Address: 21 Oldroyd Way Dewsbury WF132JJ

Application number: 2025/90207	
What is the application for?:	Erection of single storey side extension
Address of the site or building:	23, Oldroyd Way, Dewsbury, WF13 2JJ
Postcode:	WF13 2JJ

02 Proposed Site Plan
Scale 1:200 @ A2

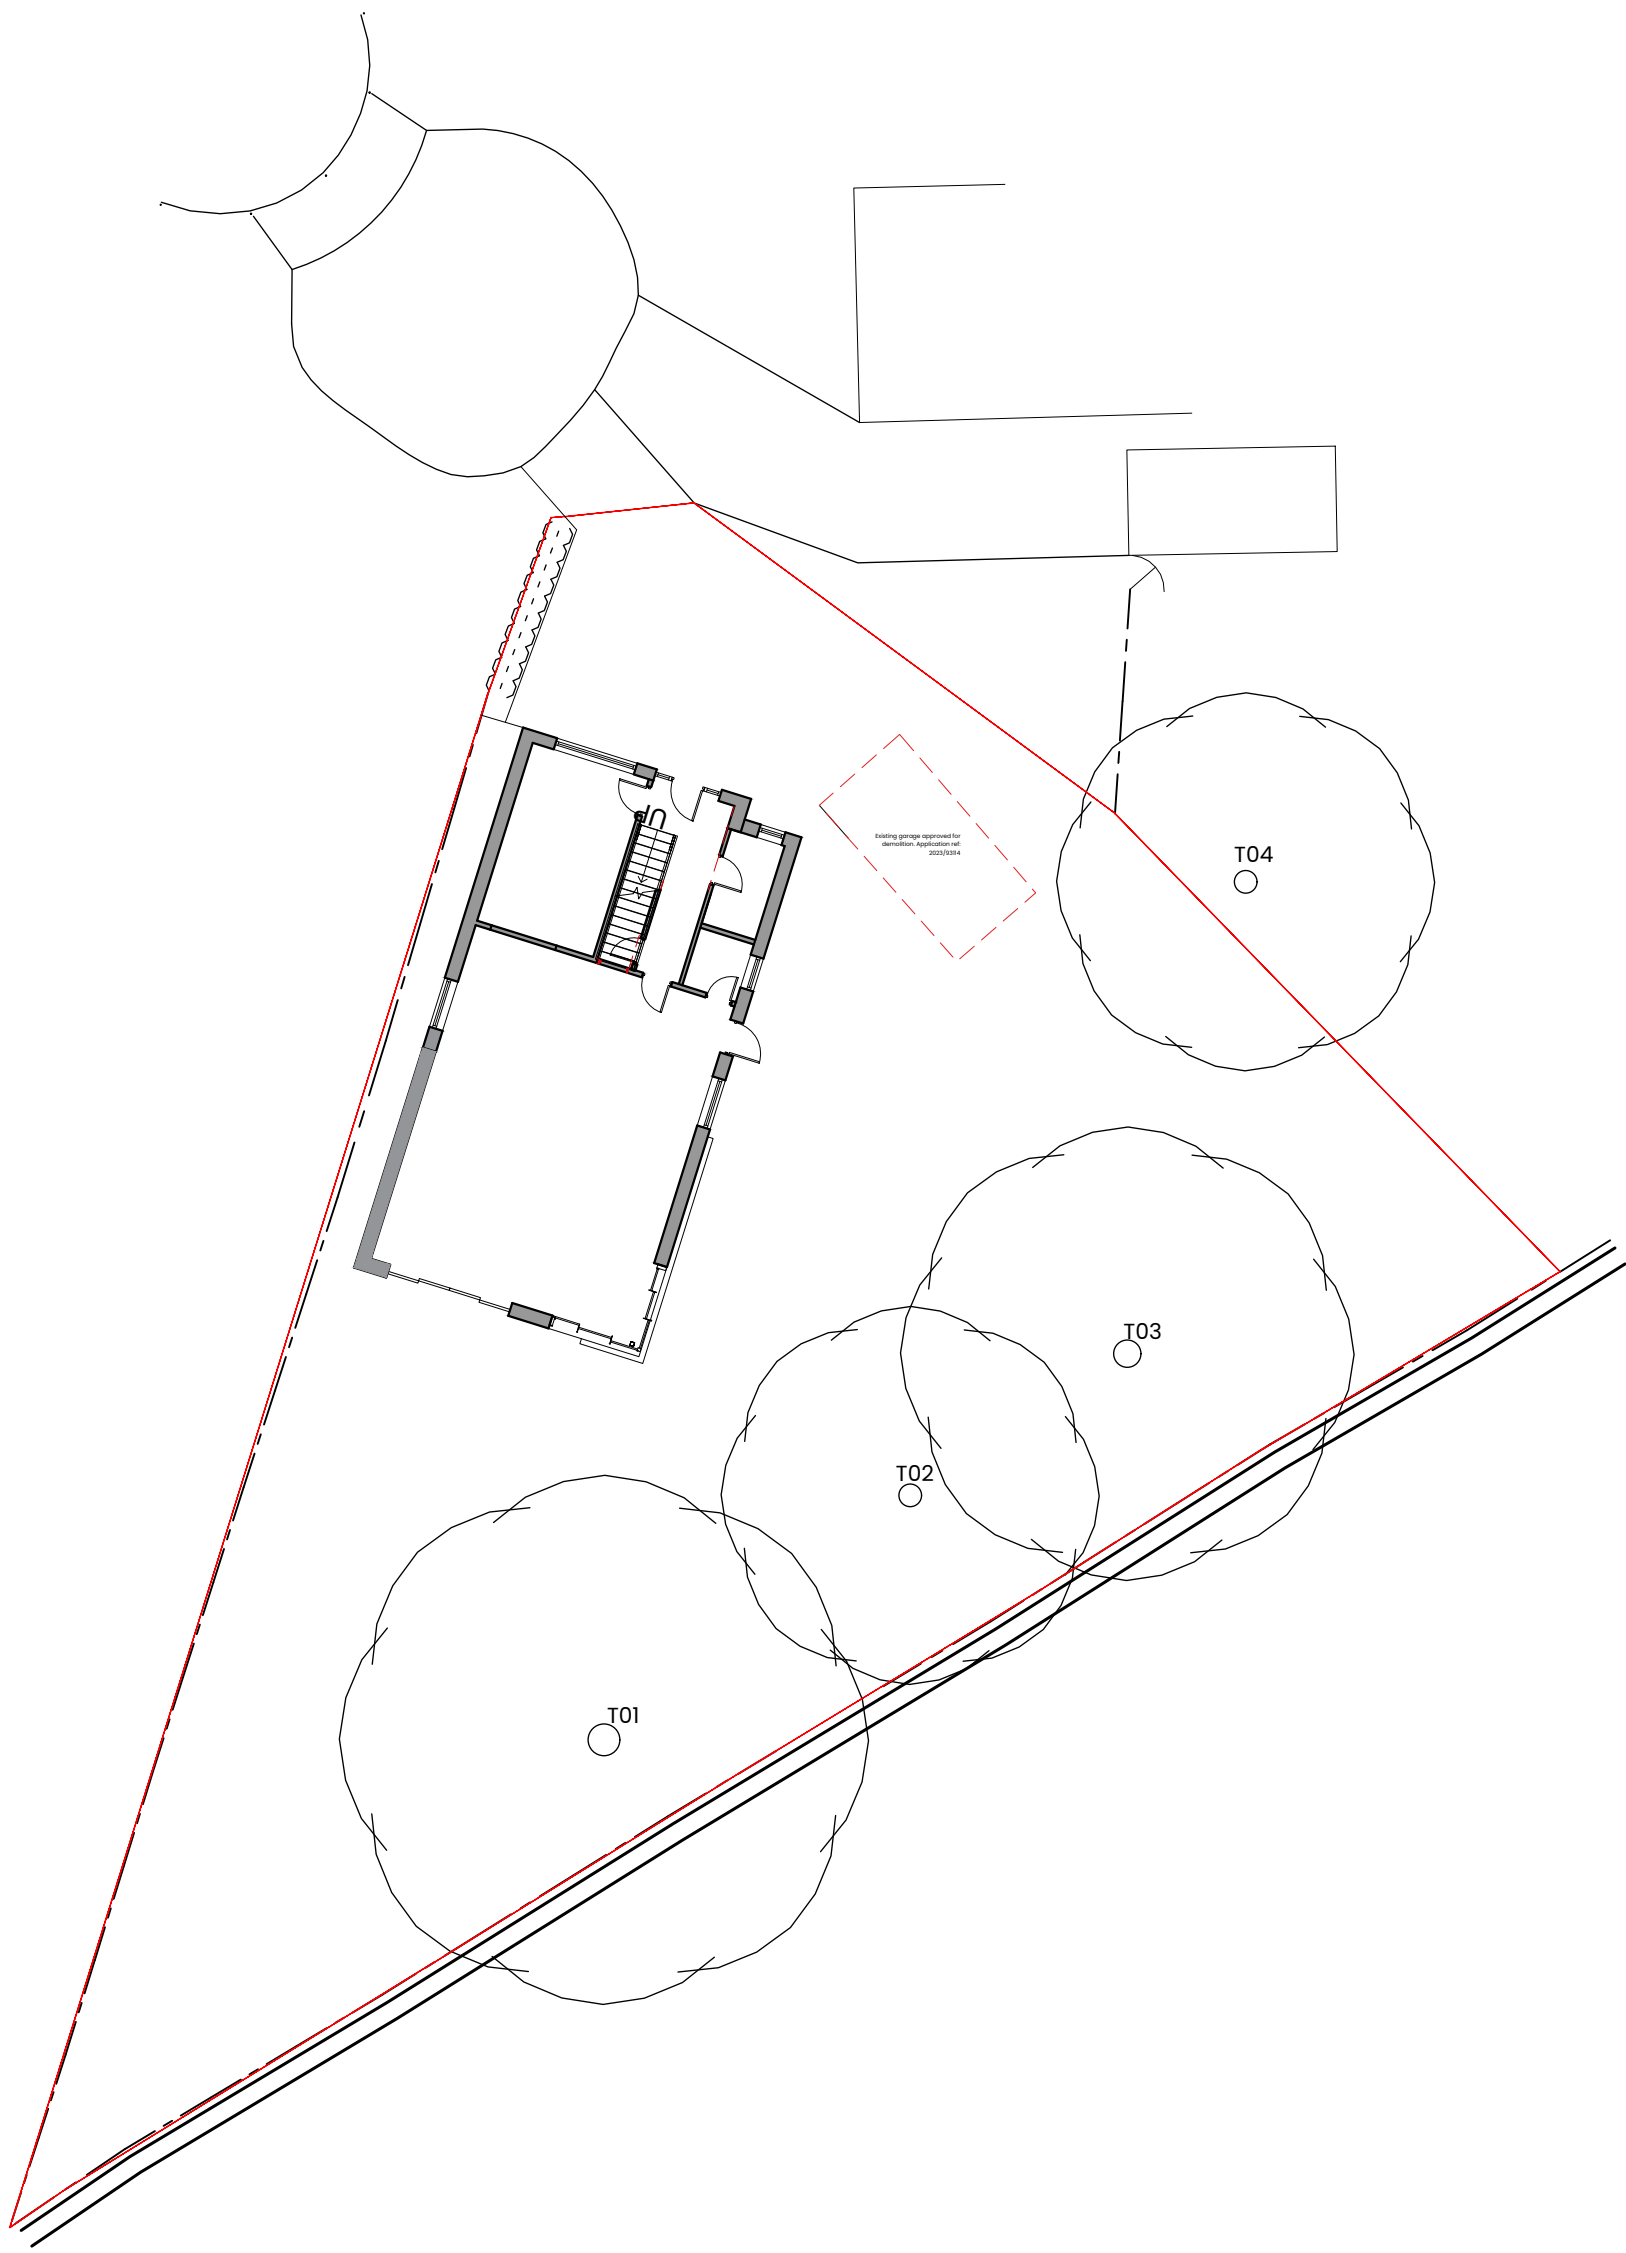
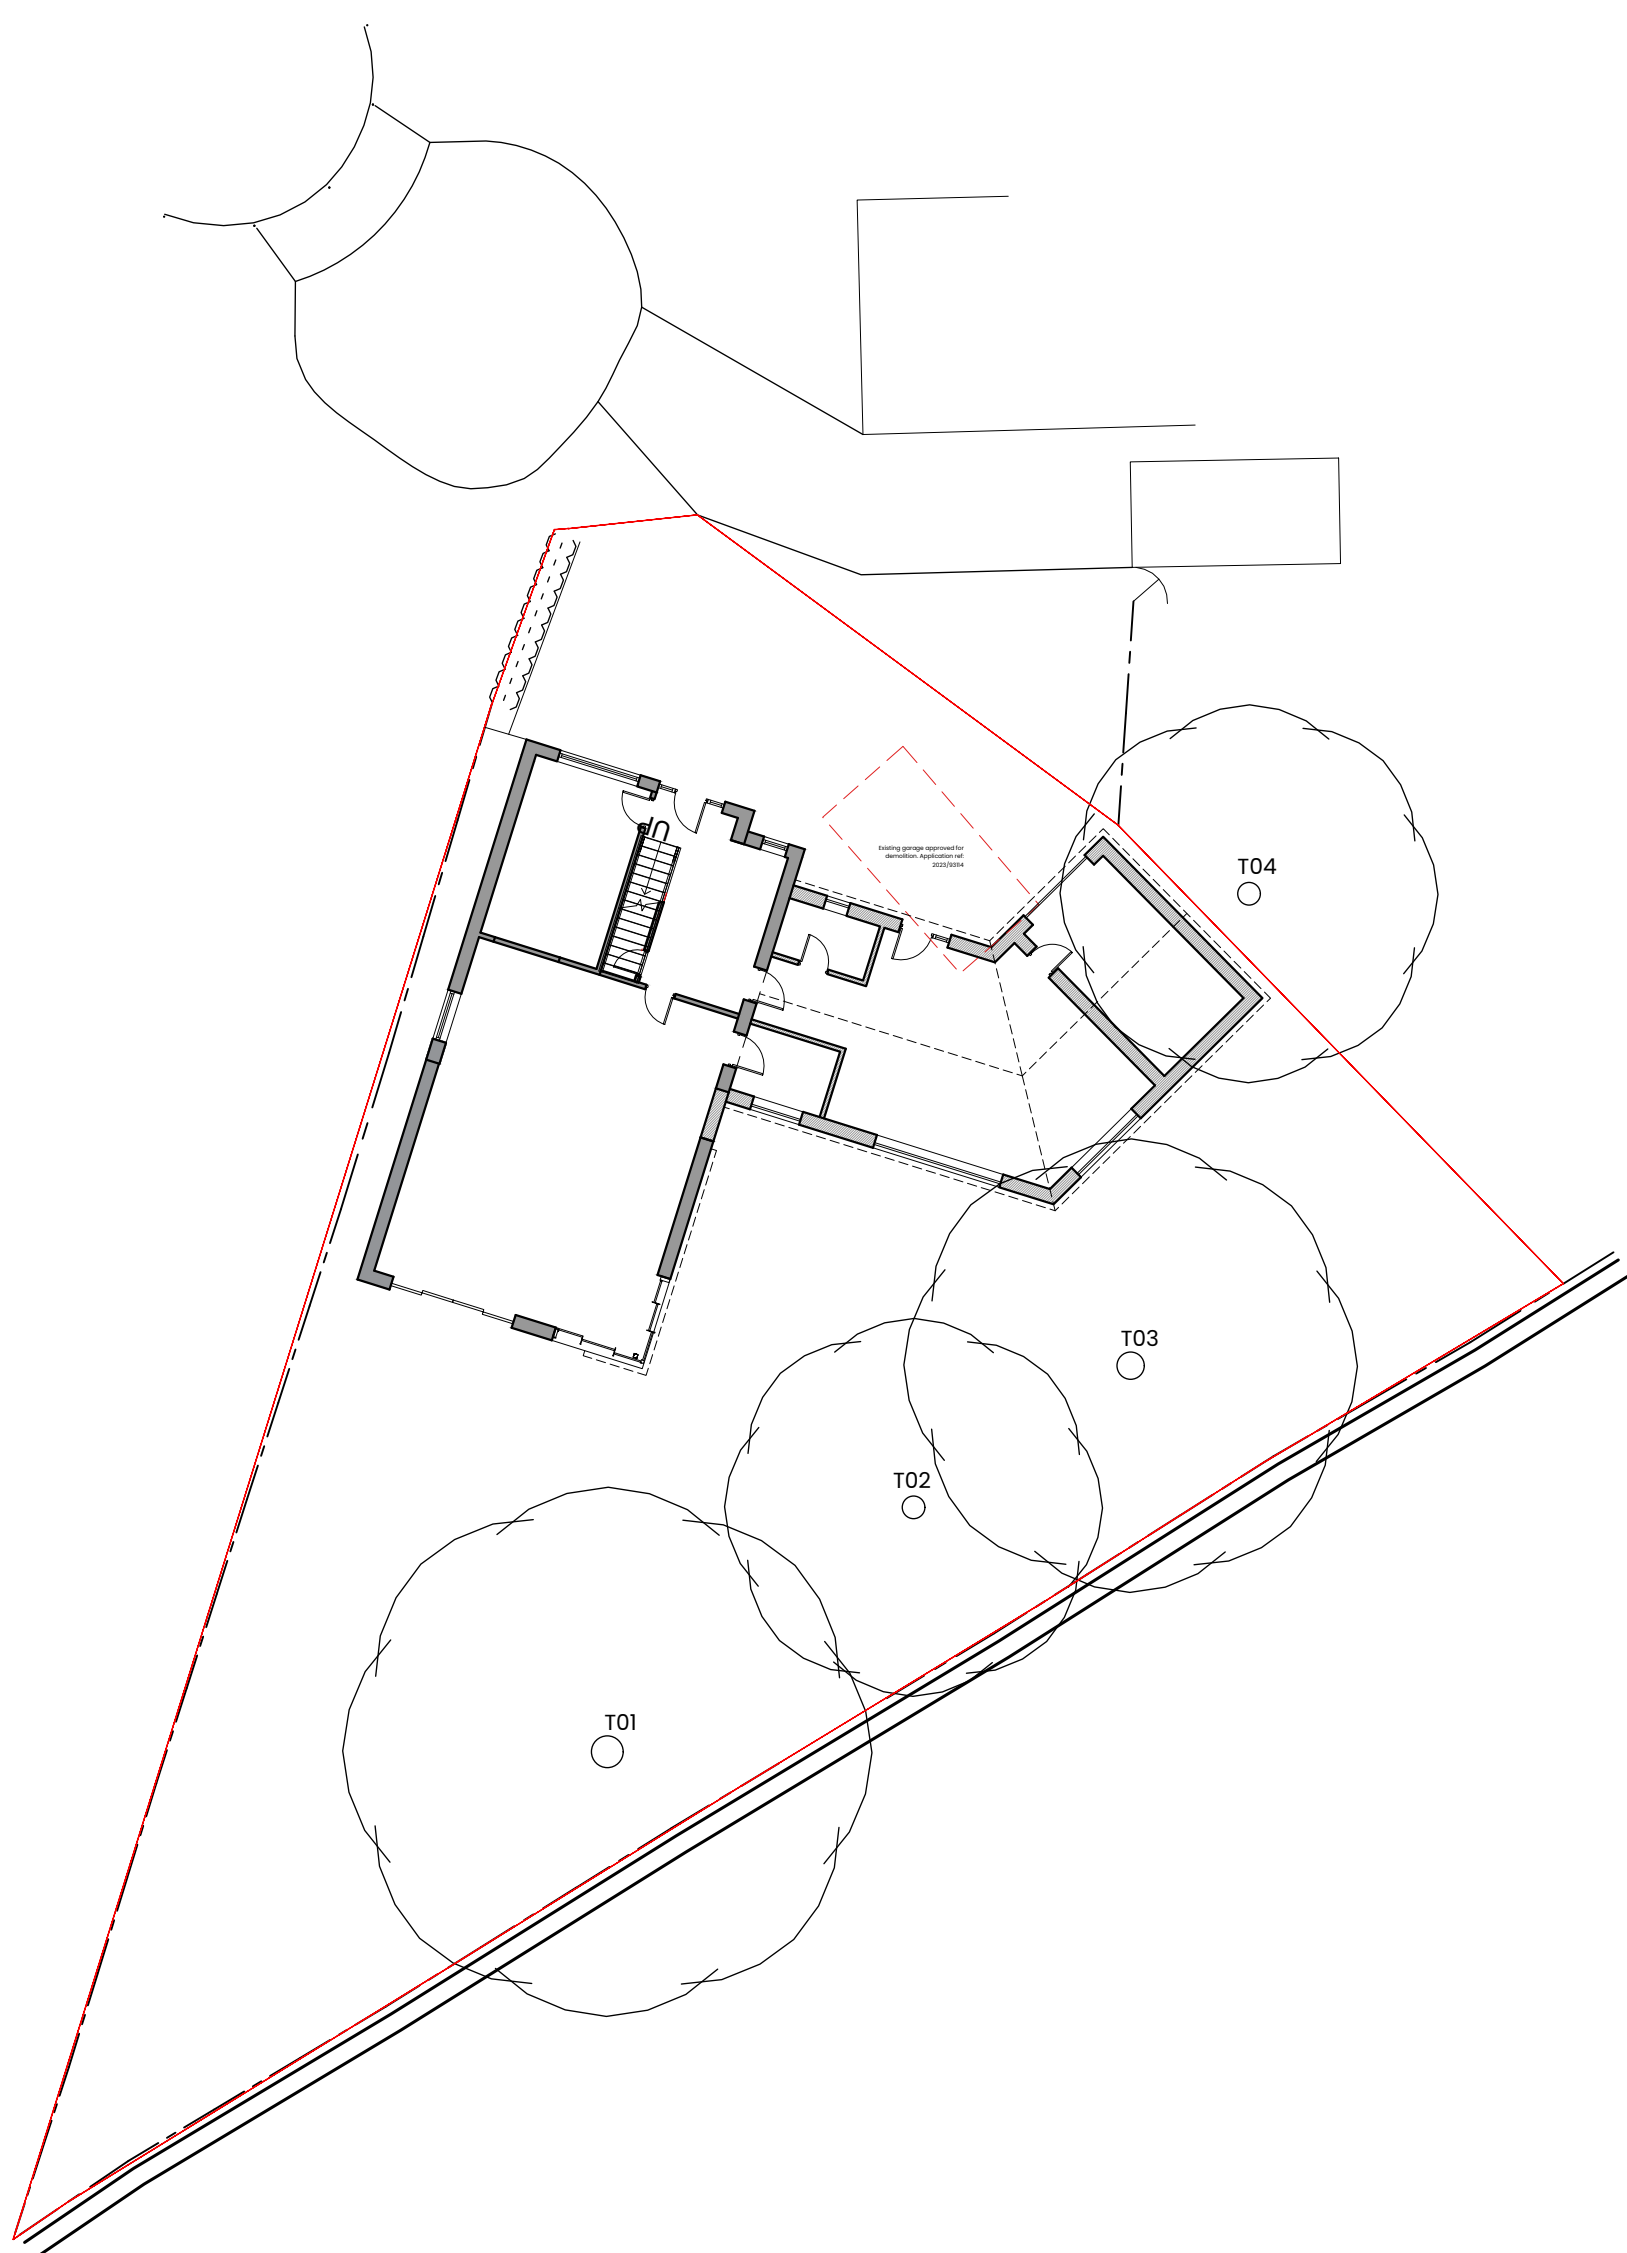
Type of comment: An objection	
Do you wish your comments to be published on the website anonymously?	No
The additional single storey extension is unacceptable 1.The size of the overall extension would be way beyond that of adjacent and nearby dwellings and therefore not in keeping with the area. 2.Surely the extension is far too near the protected tree in property No. 10s garden there is no doubt that the root system would be compromised . 3.Further accommodation means the likelihood of further vehicular traffic across the turning circle ,into what only can be described as a very small access.This would be a safety issue when vehicles from adjacent properties are using the turning circle. 4.We are annoyed that we have not been personally informed of this proposal as we are directly affected by it if it goes ahead.We were informed by letter of the original extensions.It was just by chance that we looked at the planning applications that we became aware
